Recommendation Report for Planning Permission for Works or Extension to a Dwelling

REF NO: AW/327/19/HH

LOCATION: 7 A'Becketts Avenue
Aldwick
PO21 4LX

PROPOSAL: Single storey side & rear annexe extension.

sheet 1 of 3

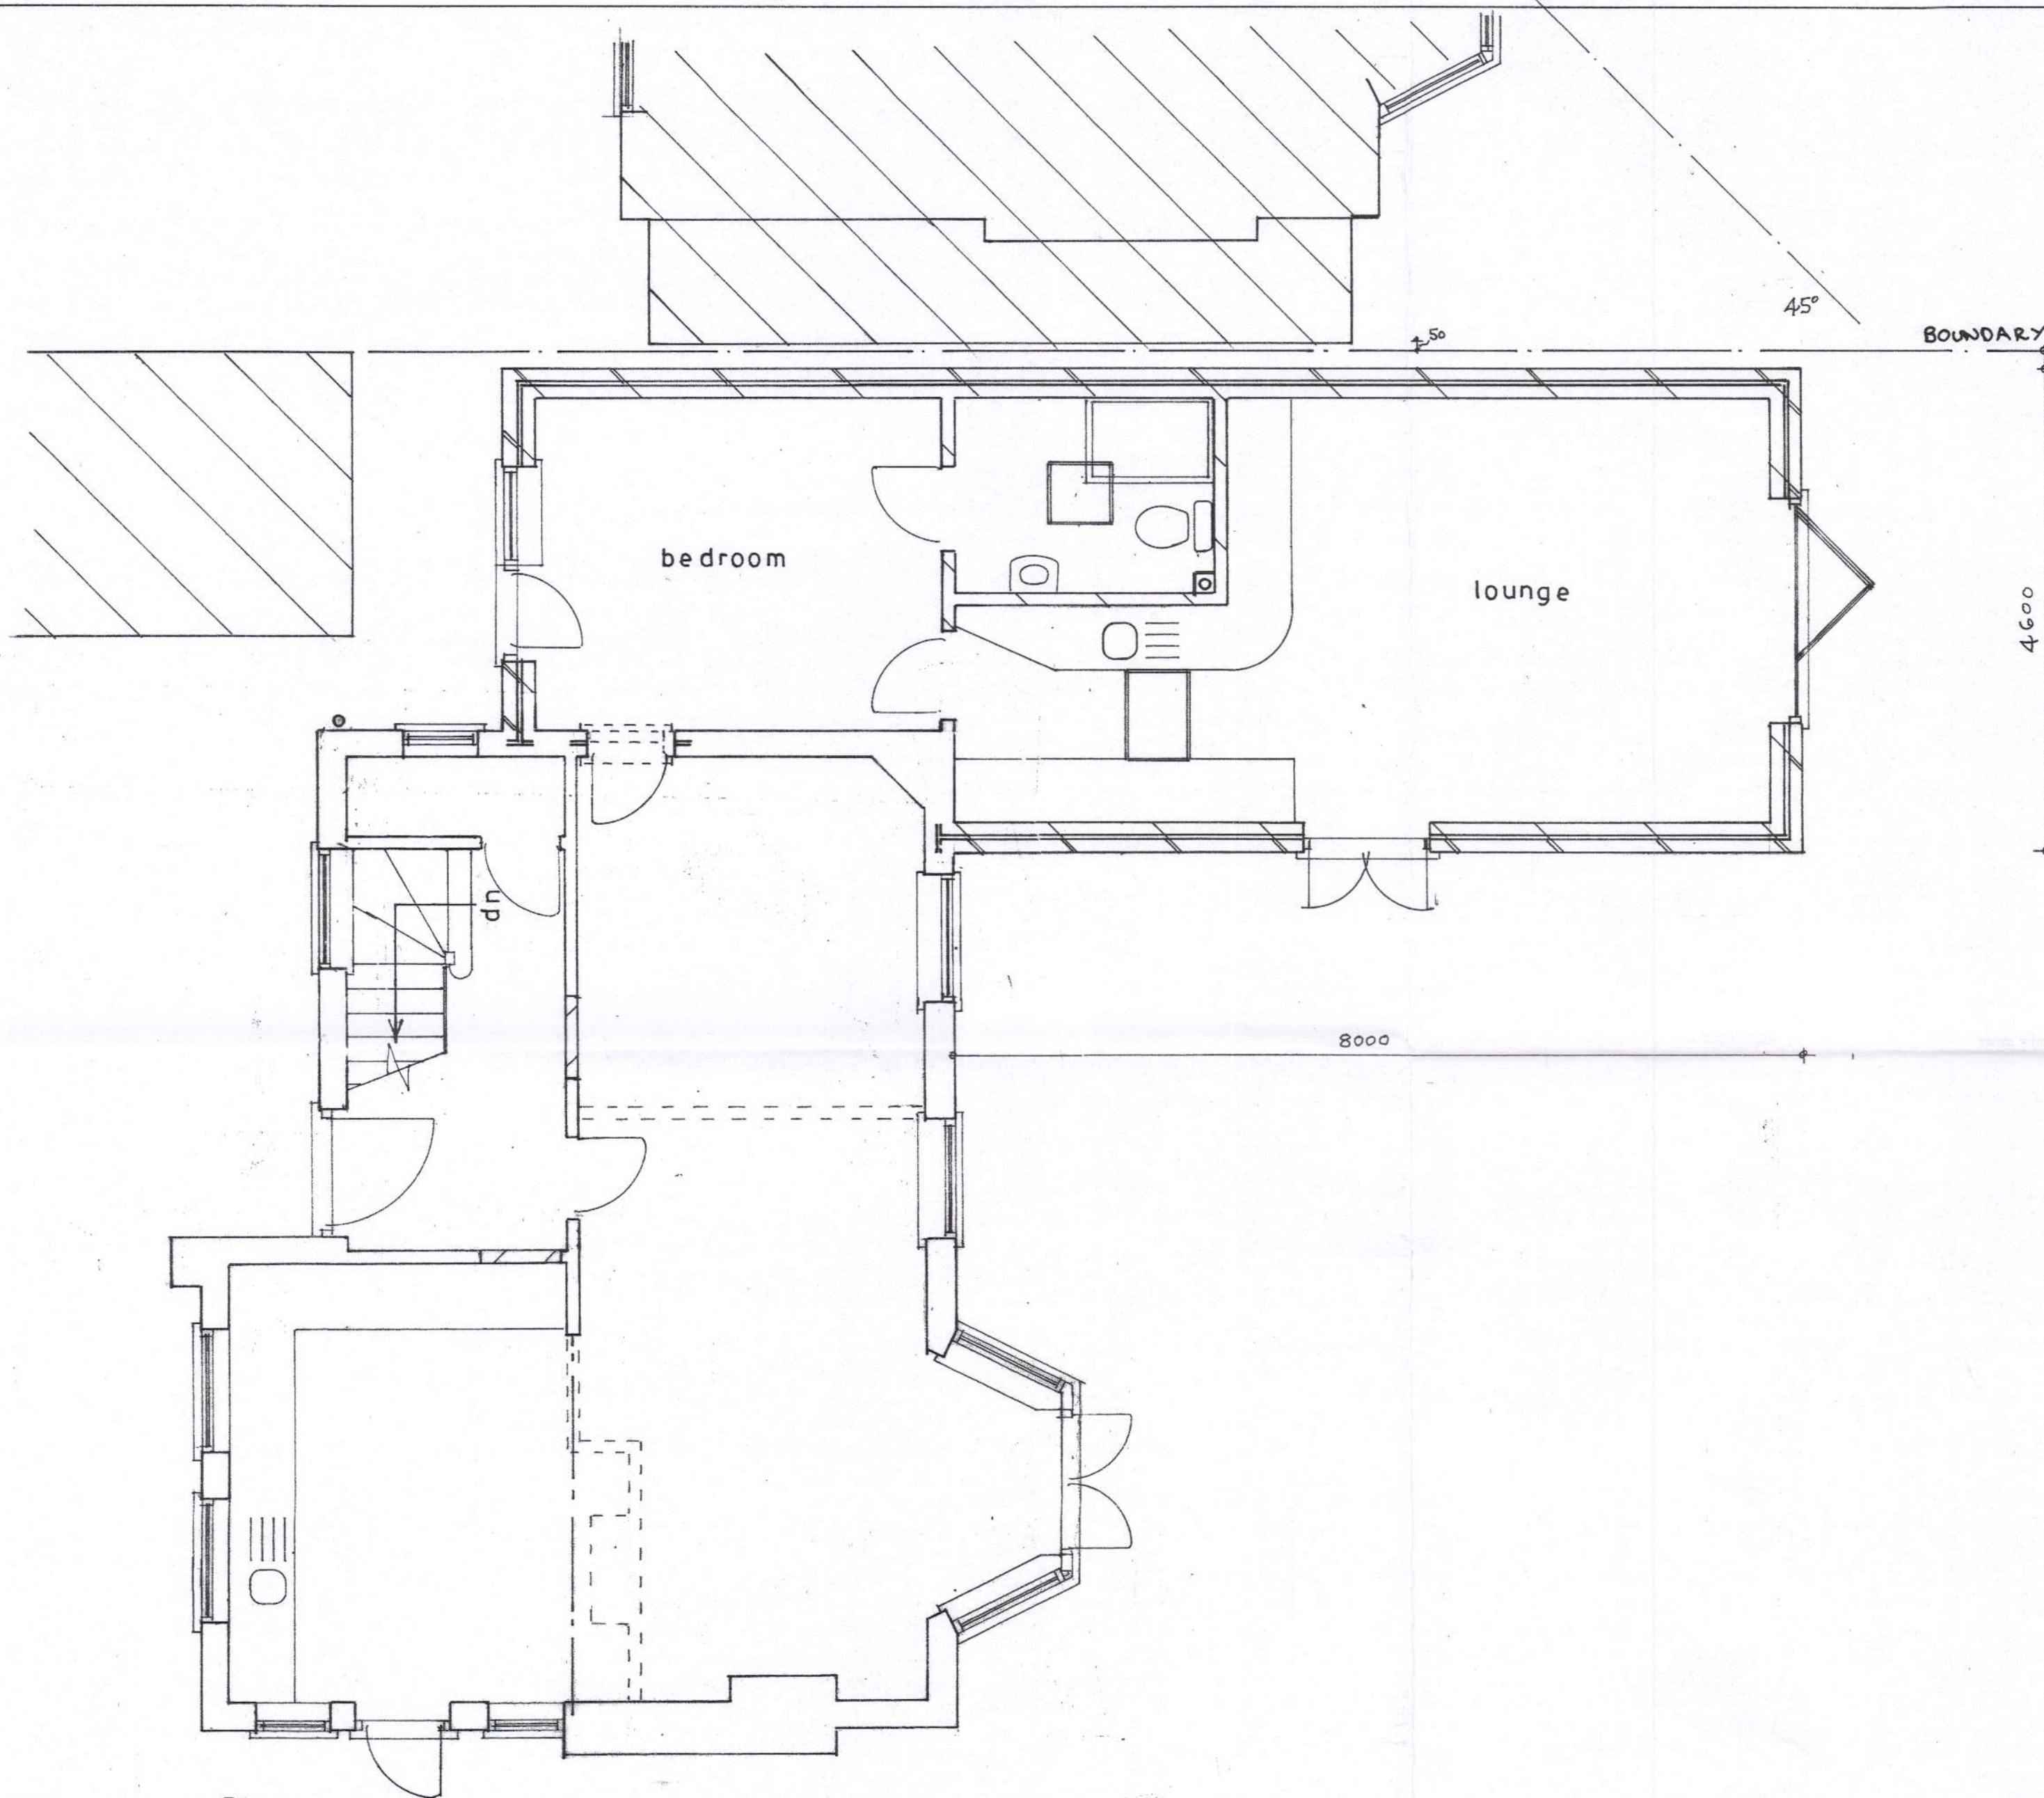
The proposed development is not considered to have any significant impact upon the residential amenities of neighbouring dwellings. The proposed construction would be located 14.8m from the western boundary, 10m from the northern boundary and 13.25m from the eastern boundary. The proposed windows are not considered to gain any views of any neighbouring dwellings. As the proposal is single storey it is considered to mitigate any potential for loss of privacy.

sheet 2 of 3

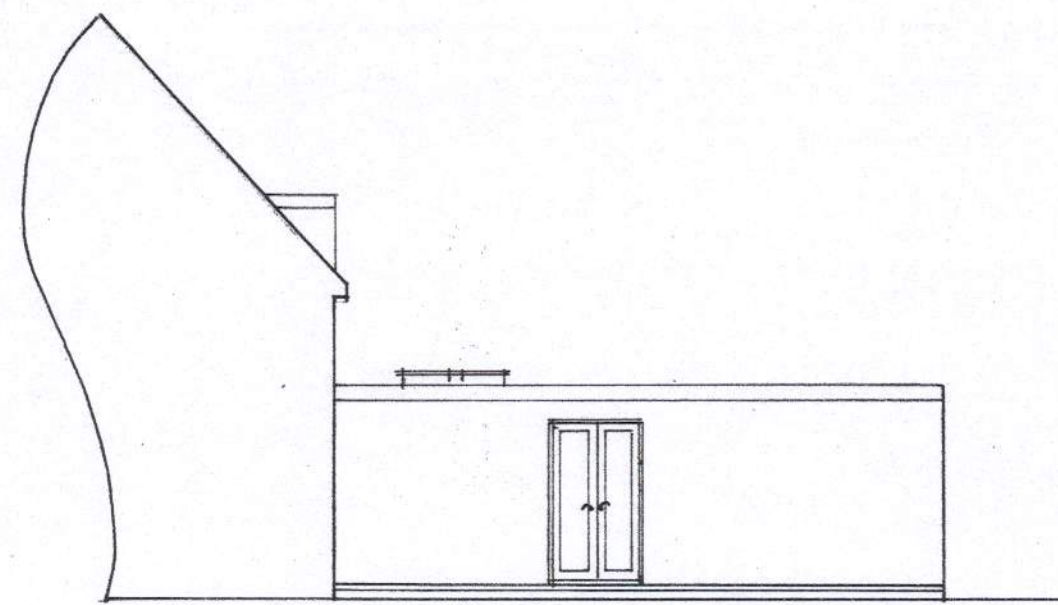
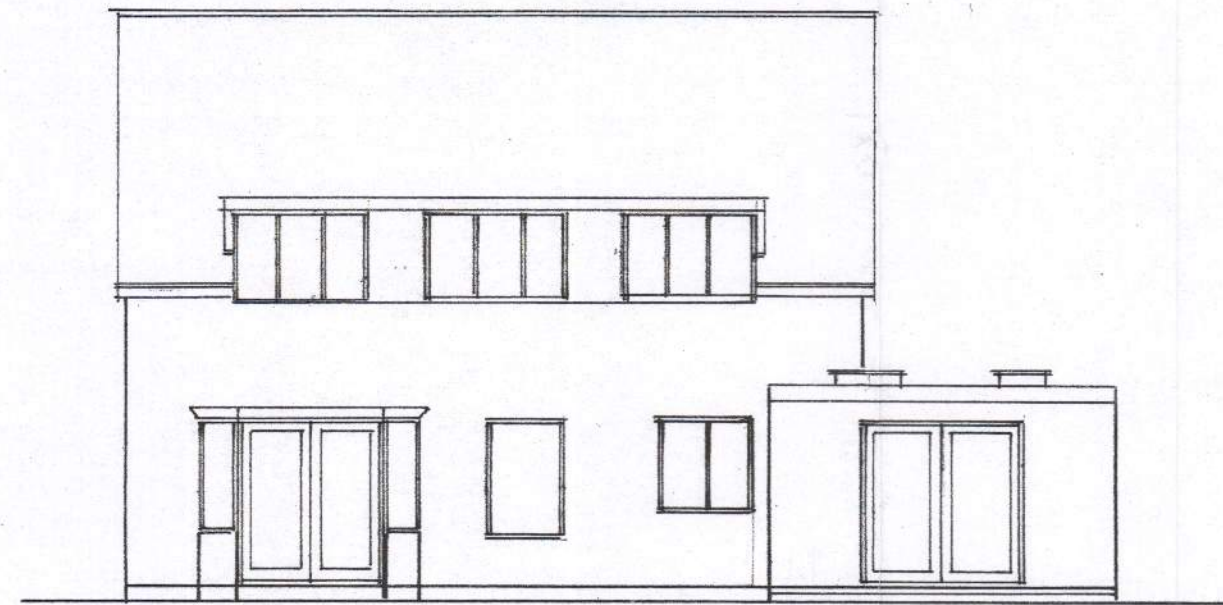
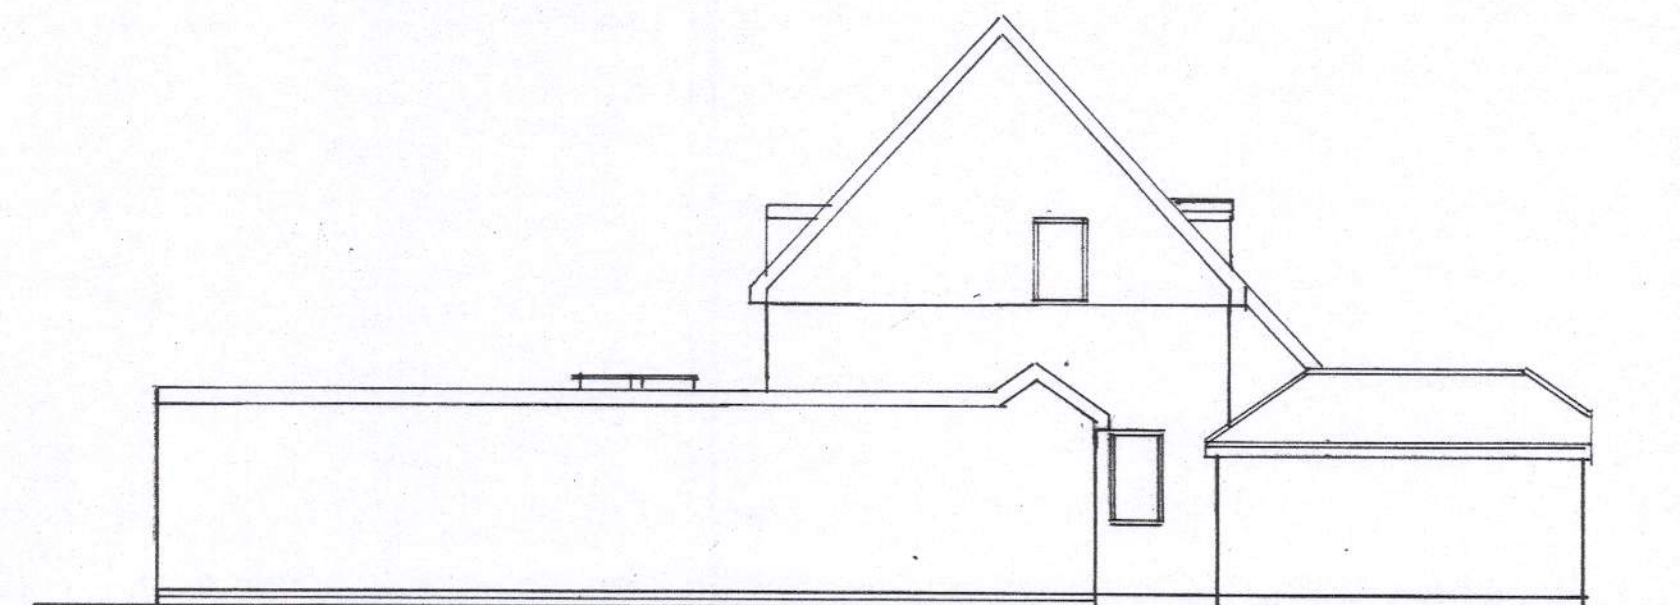
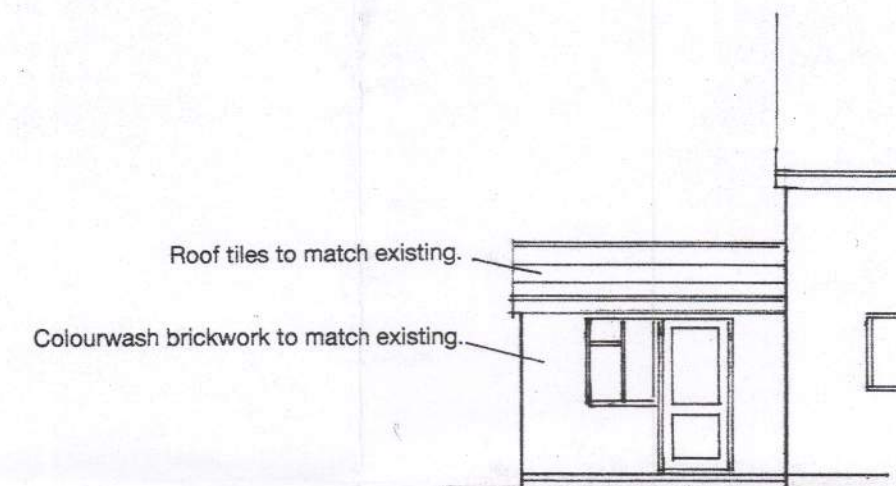
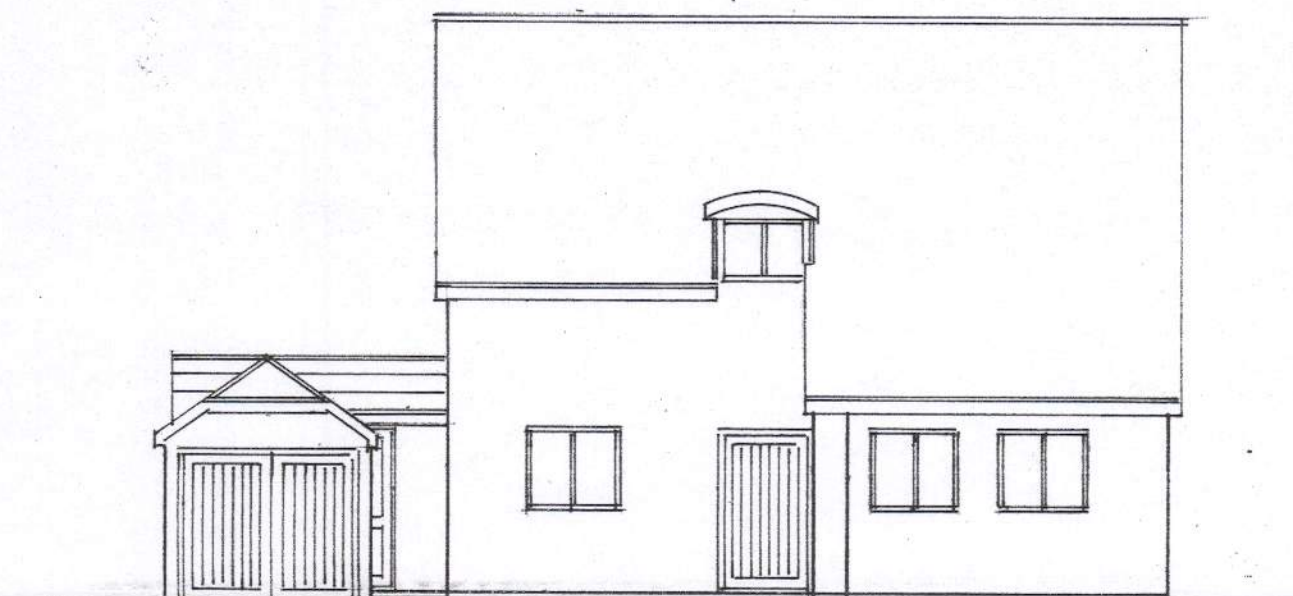
Whilst the proposal is partly visible from the street scene, it is not deemed to have a significantly detrimental impact on the established spatial pattern, or visual amenity of the area. This is predominantly due to the proposed materials and modest, scale of the development allowing it to remain subservient in appearance and sympathetic in style to the host dwelling. A further reason the proposed is not considered have a detrimental impact on the visual amenity of the area is because the existing garage remains and obscures most of the views of the extension.

The proposed extension is considered to be acceptable in terms of design and visual amenity, in that they do not have any considerable impact upon the street scene, or the established character of the site. It will measure approximately 12.5m in depth and 3.75m in width on the front elevation and a width at the rear of 4.75m. The proposed French doors on the western elevation are not considered to have a demonstrably negative impact on the appearance of the building or to have to an impact upon overlooking due to the ground floor views over the rear garden which are screened by a fence and would only look out over the public highway. The proposed skylights is not considered to raise significant impact on over looking due to positioning and the views gained not being of the neighbouring properties. The window and door to the front look over the front garden and to the road with a garage in the way of the views as such are deemed to be in accordance with the relevant policies.
